**RE: Burgerworks Monument Junction– Initial Review Comments**

In regards to the initial comments received for Burgerworks Monument Junction Prelim/Final PUD Plan we have provided the associated responses below in **red**.

LOT 4 MONUMENT JUNCTION WEST FILING NO. 1 PRELIMINARY/FINAL PD SITE PLAN PRELIMINARY UTILITY PLAN				
	DESIGNED BY	CMT	SCALE		DATE
DRAWN BY	CMT	(H) 1" = 30'	SHEET	5 OF 13	
CHECKED BY		(V) 1" = N/A	JOB NO.	2589.20

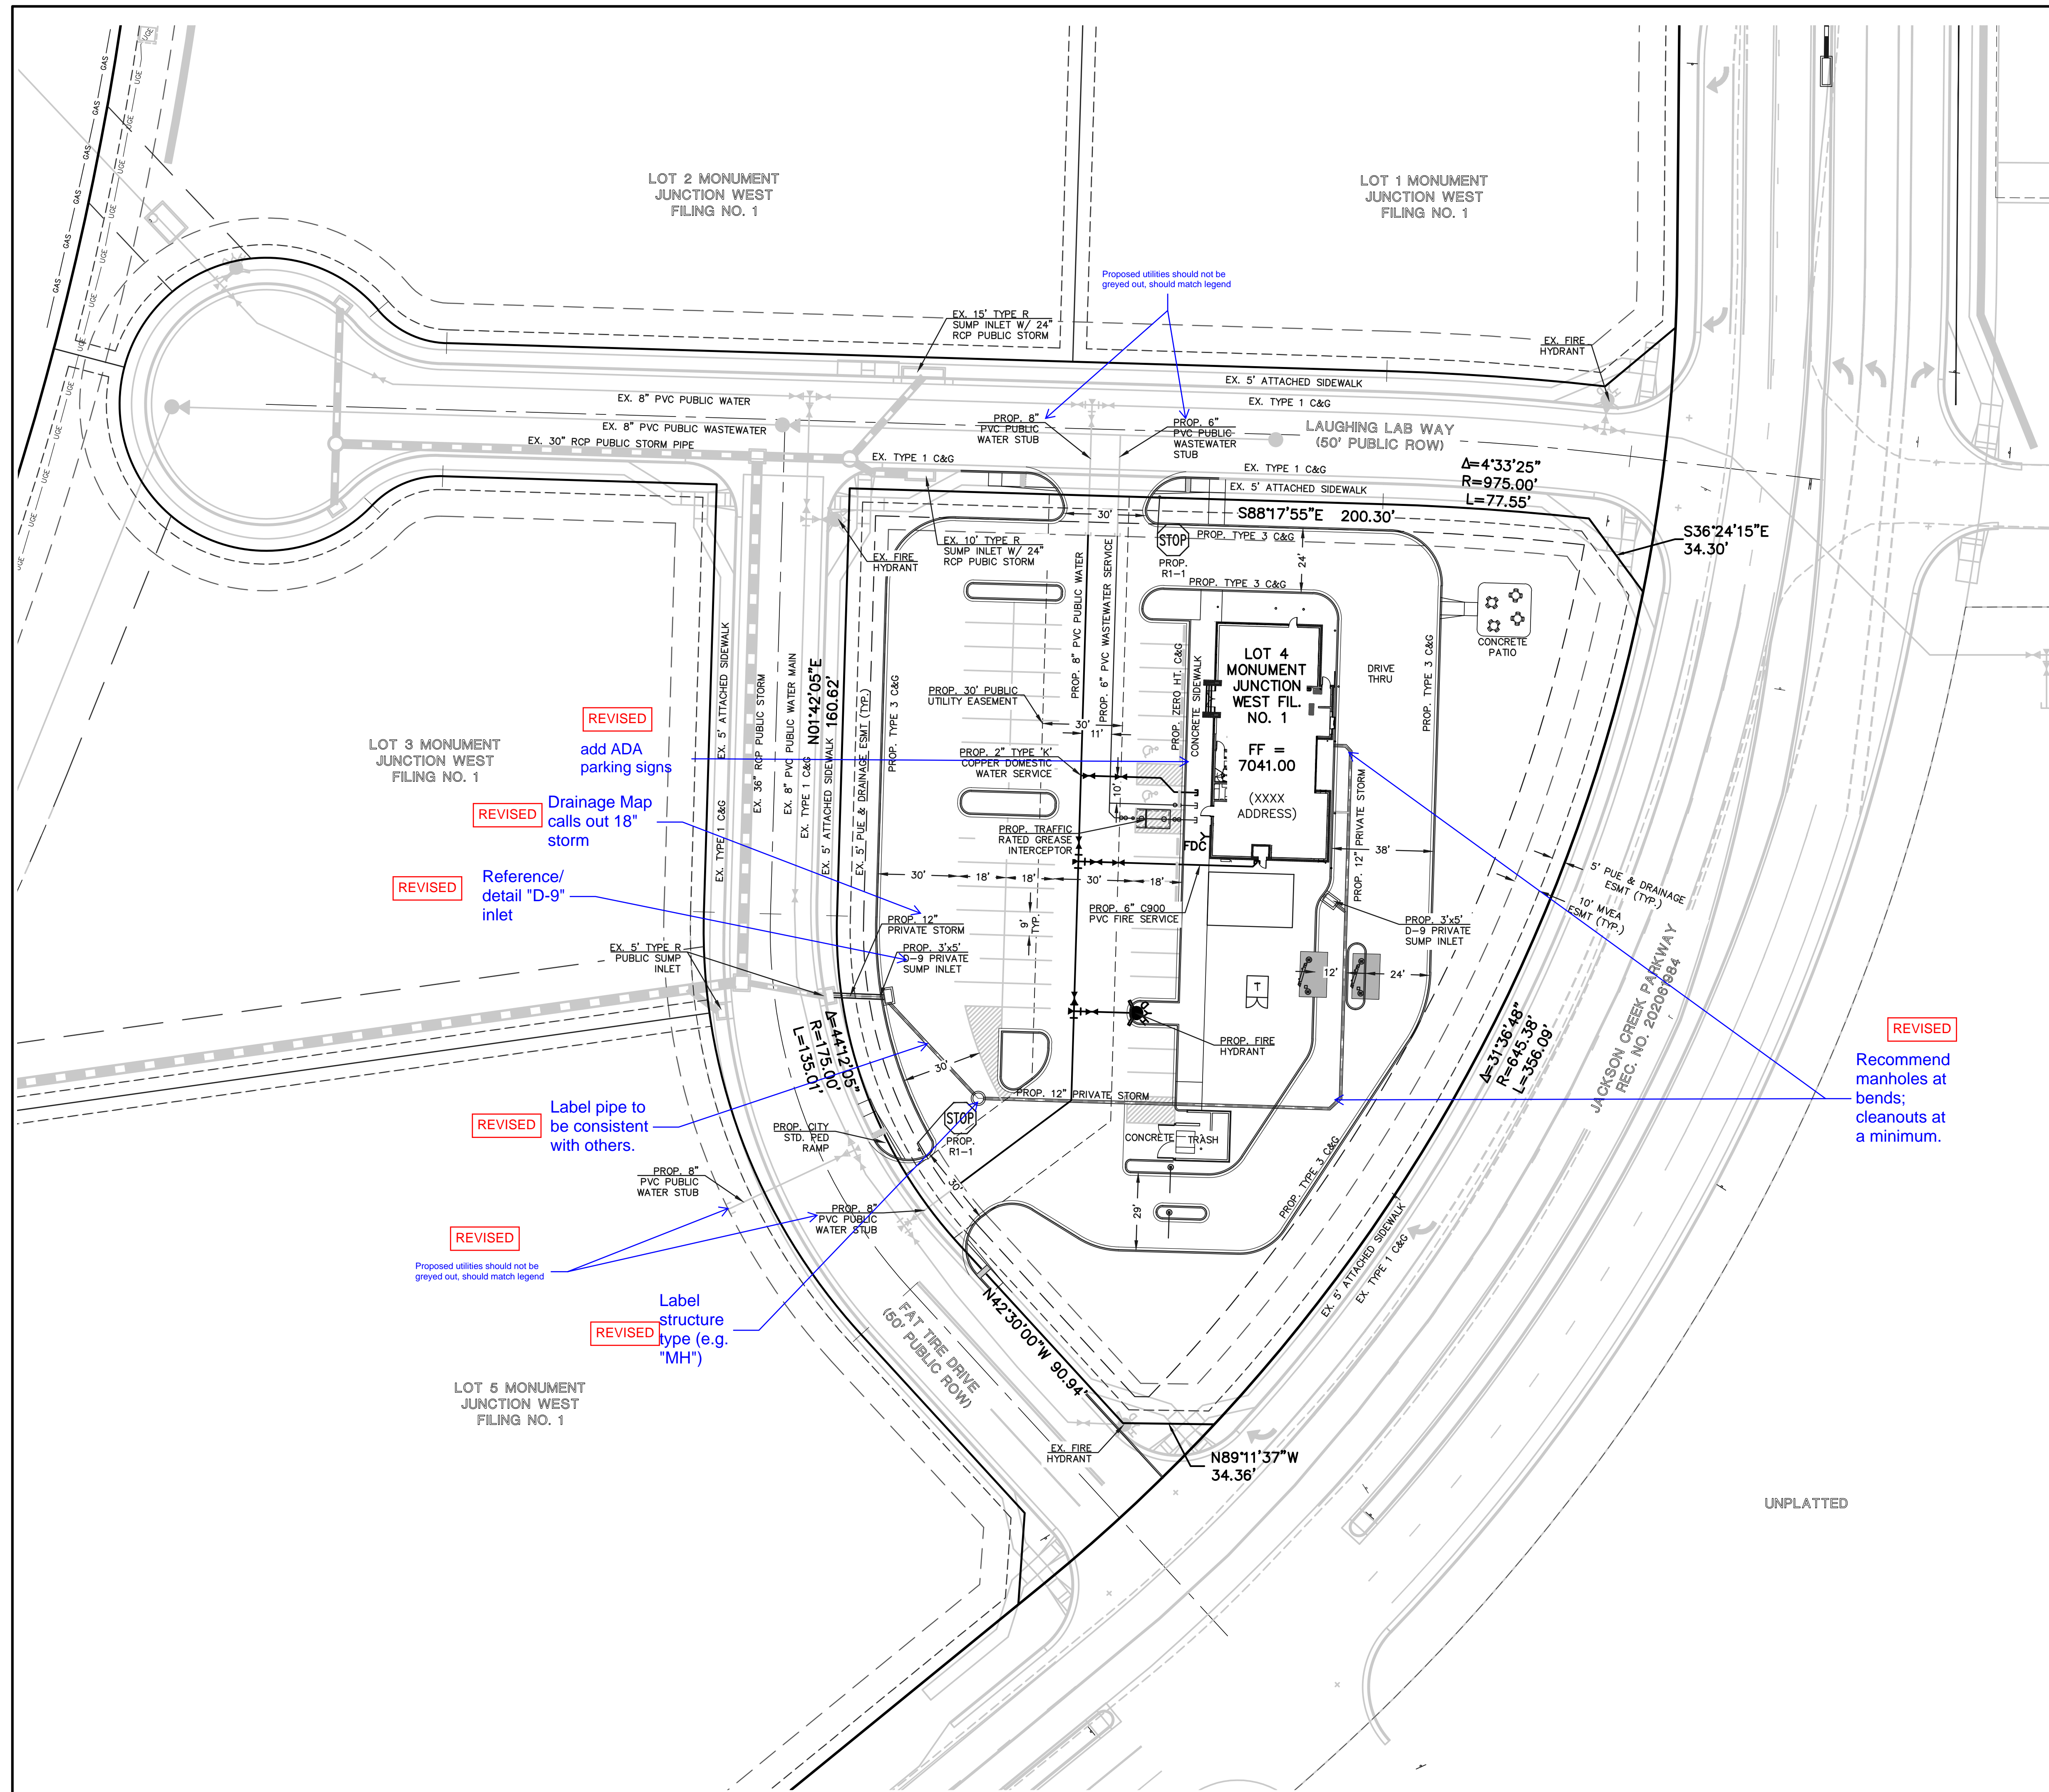
1. Please add a monitoring manhole to the 6" sanitary sewer service line. This can be the connection to the sewer mainline within Laughing Lab Way. If it is preferred to be closer to the building, the District will need an easement for the monitoring manhole if it is inside Lot 4 property lines.

2. Please provide a detail of the 6" fire service line which shows adequate backflow prevention. All fire lines must be ductile iron pipe.

3. The District does not feel there is a need for a water main loop within Lot 4. a. Are you able to connect your water service and fire suppression service lines to the 8" water mainline within Fat Tire Drive? i. The District will need easements if curb stop is outside of ROW and within Lot 4 property line. District preference that the location of curb stop boxes is outside of pavement and outside of concrete. b. Is there a need for a fire hydrant on the property if there is a fire suppression line to the building and a hydrant on the corner of Jackson Creek Parkway and Fat Tire Drive?

**Monitoring manhole added to plan. Easement is shown on plan.**

**Fire service to be labeled as Ductile iron pipe. Backflow prevention for fire line to be provided inside building with permit drawings to be reviewed by PPRBD. Note added to plans.**

**The water main loop provides redundancy for continuous connection to the fire line, domestic service and fire hydrant (Section 3.2.4 Note 5 Re: looping). The fire hydrant is located within 100 feet of the FDC as proposed. The Hydrant at Jackson Creek Pkwy and Fat Tire Drive is over 300 (driving distance) feet away. A 30' easement has been shown on the plan to encompass the water main. Valves are shown at each connection for the main to isolate Lot 4.**
